From: Marilyn O'Neill <marilynoneill59@gmail.com>
Sent: Tuesday, June 1, 2021 5:28 PM
To: Lauren Anderson
Subject: Comments on short plat application SUB21-002
Attachments: Marilyn's letter.pdf

PURPOSE: Comment on the preliminary short plat application SUB21-002

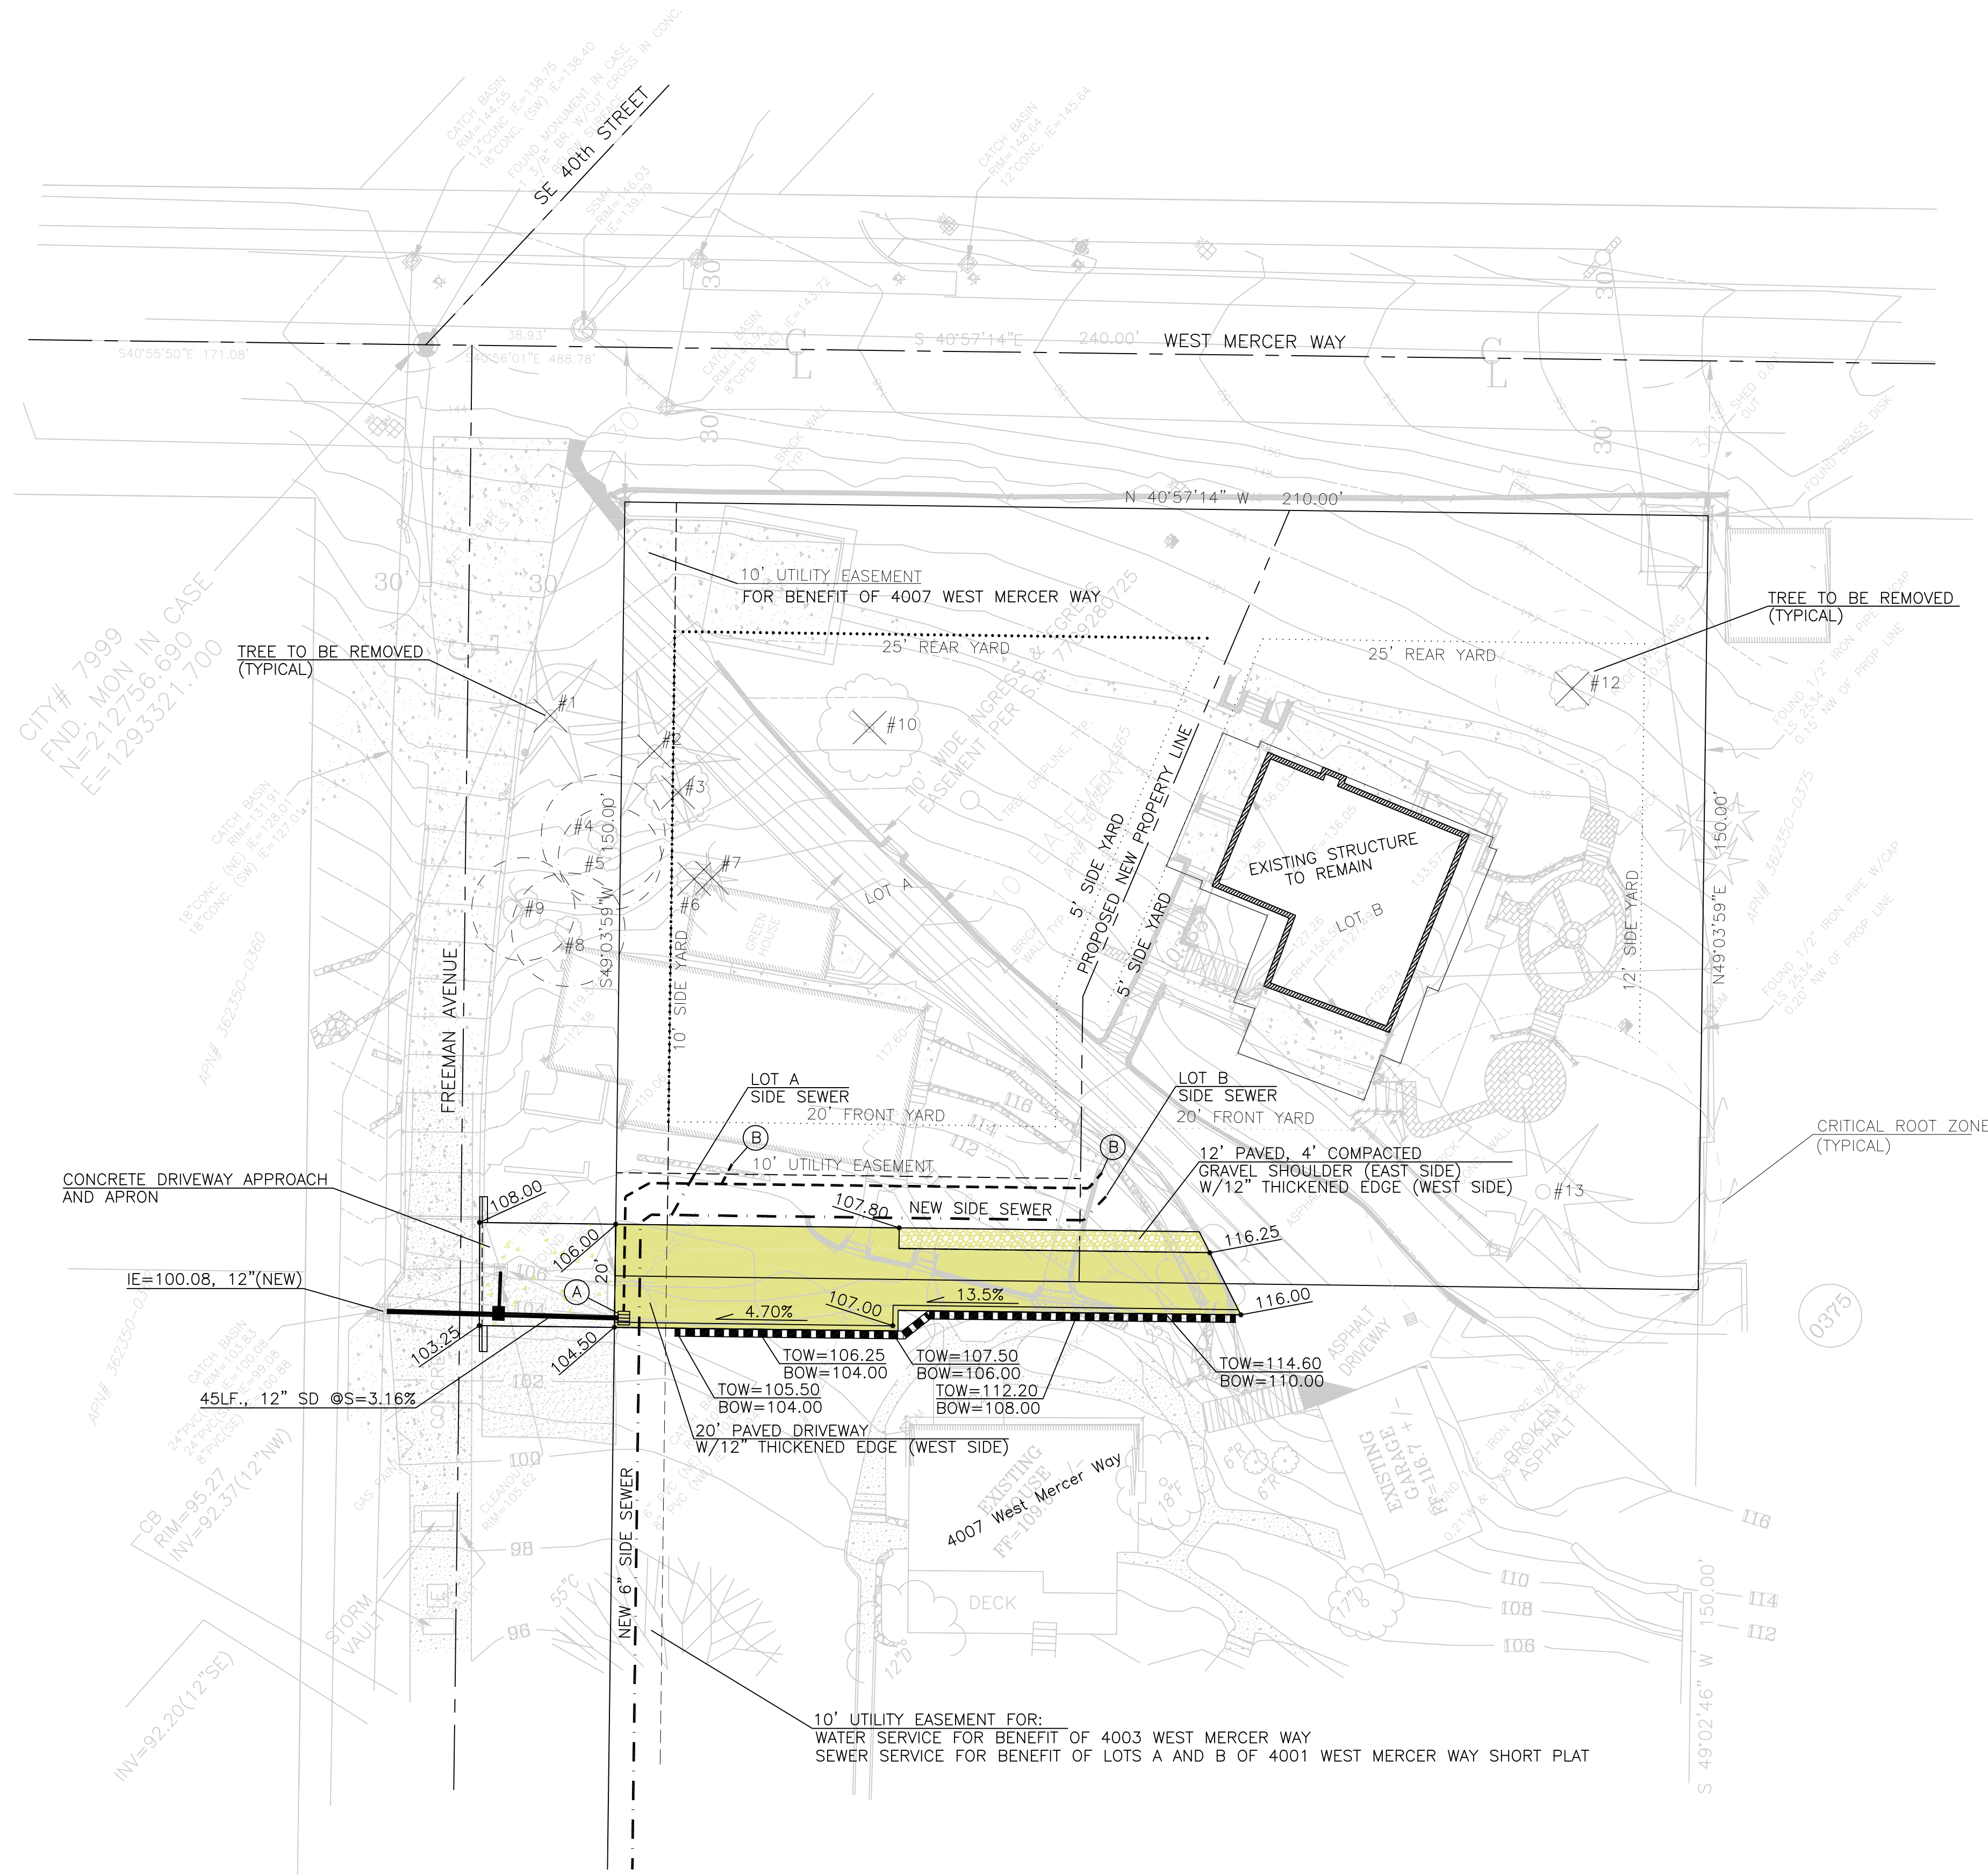
The large storm drain that comes from West Mercer underground continues to be over-burdened as more houses are built. In recent years, city public works employees have used the term "it's over capacity". Voluminous water streams down the slope, filling the catch basins and roaring down to dump into the lake. The city has no records of the original pipes and infrastructure on this very old important road and adjoining neighborhood. These pipes continue to erode, become clogged and alter the infrastructure. The land cannot hold the water without mitigation.
